# CITY OF ALBUQUERQUE

February 4, 2014

RE: **2117 St Cyr St. SE**  
**Grading and Drainage Plan**  
**Engineers Stamp Date 1/10/14 (K15-D097)**

2117 ST CYR GRADING & DRAINAGE PLAN

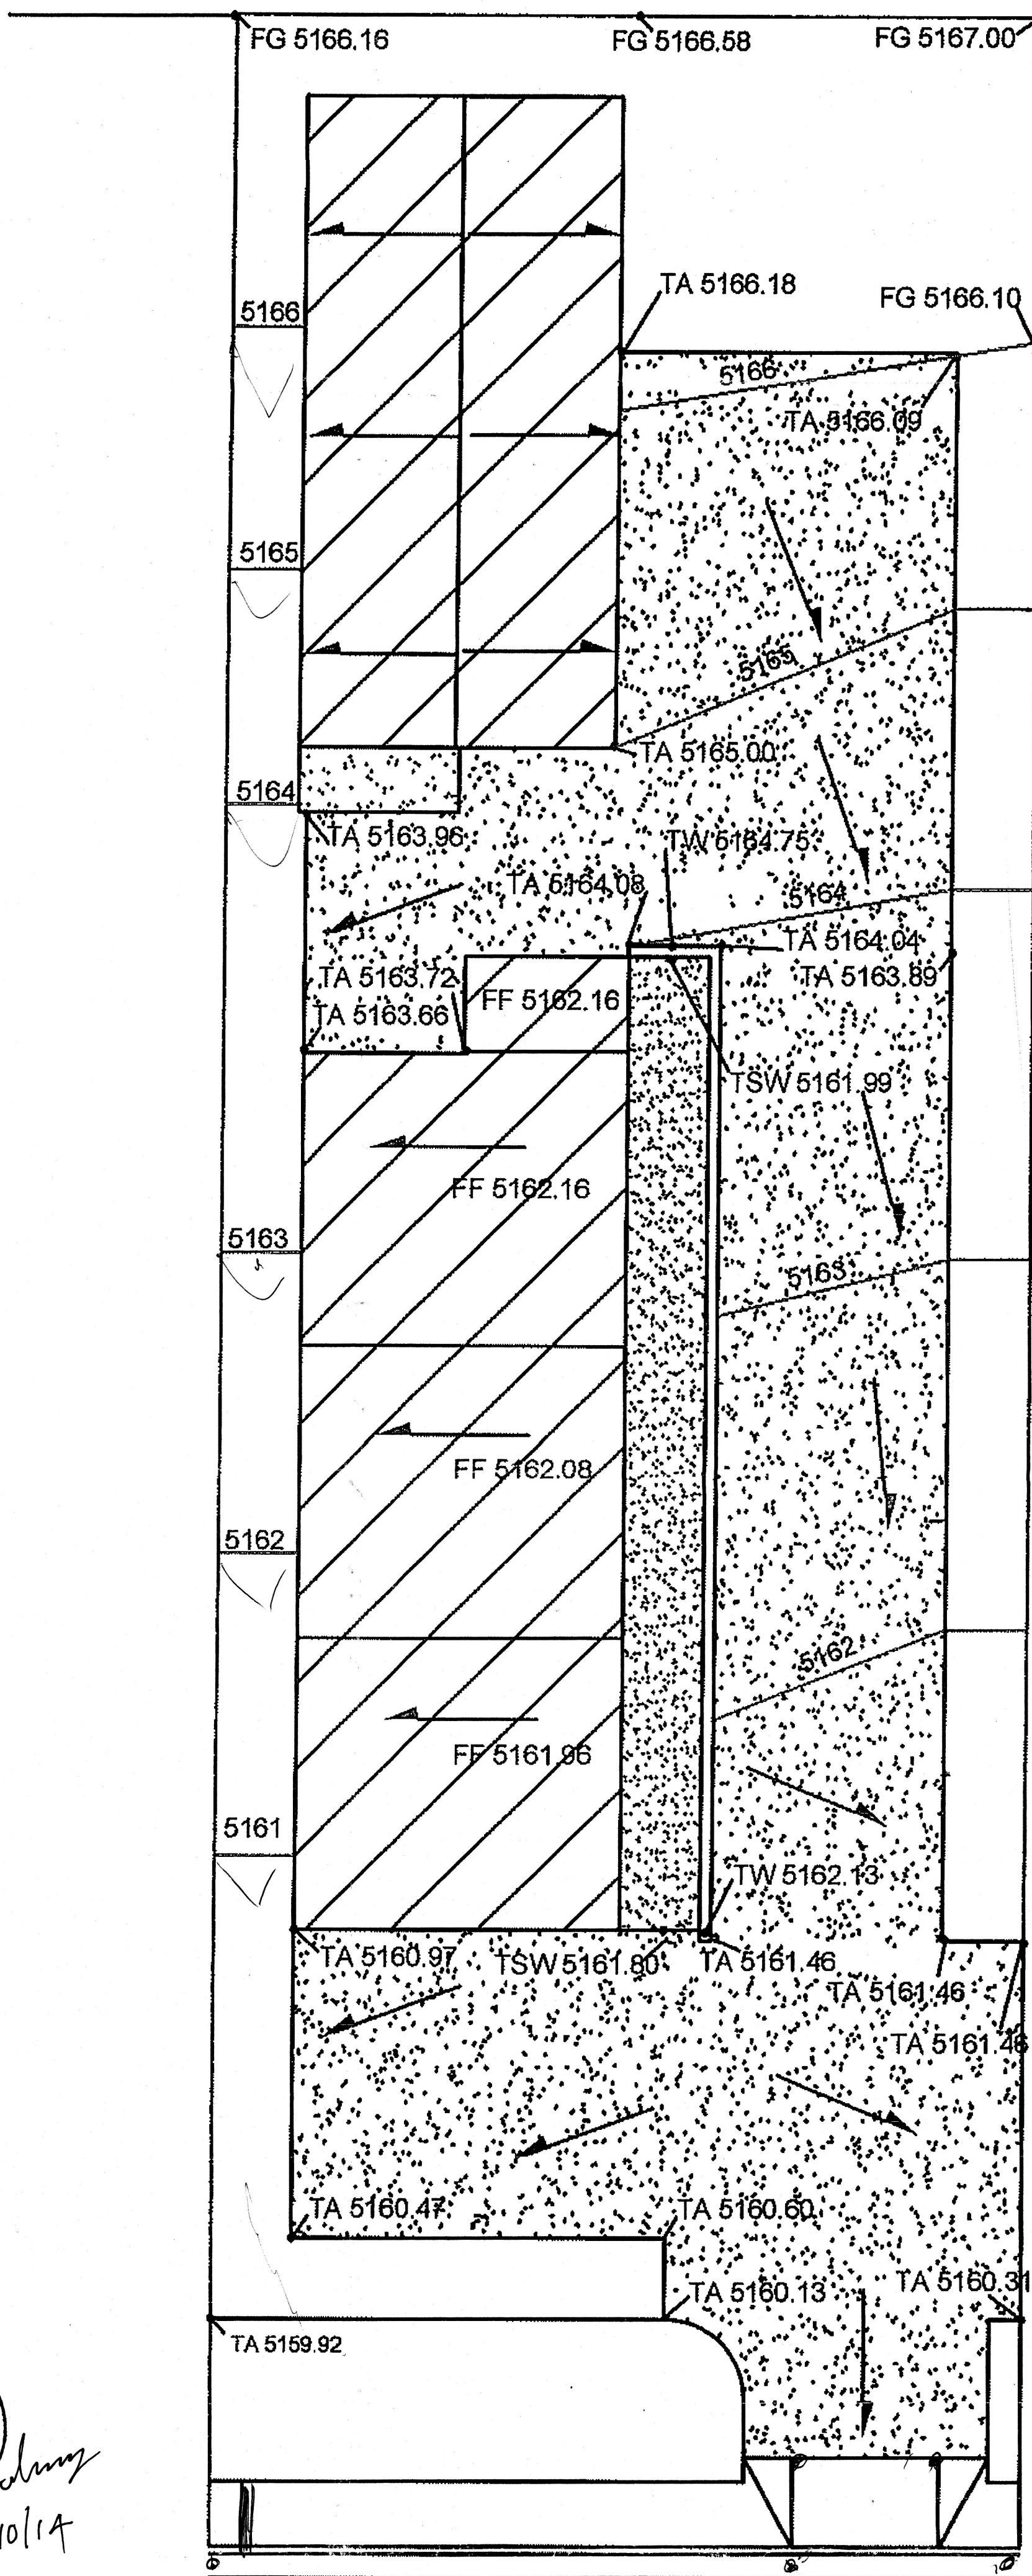
- The spread sheet with all calculations is missing. These calcs can be placed on the plan itself. Build notes are needed along with standard construction notes. A vicinity map is required. The bench mark needs to be provided.

- Is the drive pad existing, if not it should be built per city specifications. A water block should be provided at the entrance along with grades.
- How are flows leaving the site to the west of the buildings? Nuisance flows are not allowed to flow over public sidewalks. A swale should be provided to the west of the buildings along with a profile or section of the swale. If a sidewalk culvert is used provide a detail with notes.

- The FF is missing at the most northern building.
- All landscaping 10 feet away from buildings should be depressed to retain moisture which falls on them.

- Existing and proposed contours should be placed in and around the site along with flow line in ST Cyr.
- Show the property lines and all fences and or walls.

- Are the flows around the site being adversely affected? How is the alley being affected if at all?
- The north arrow is missing.
- Where is the location of the dumpster?
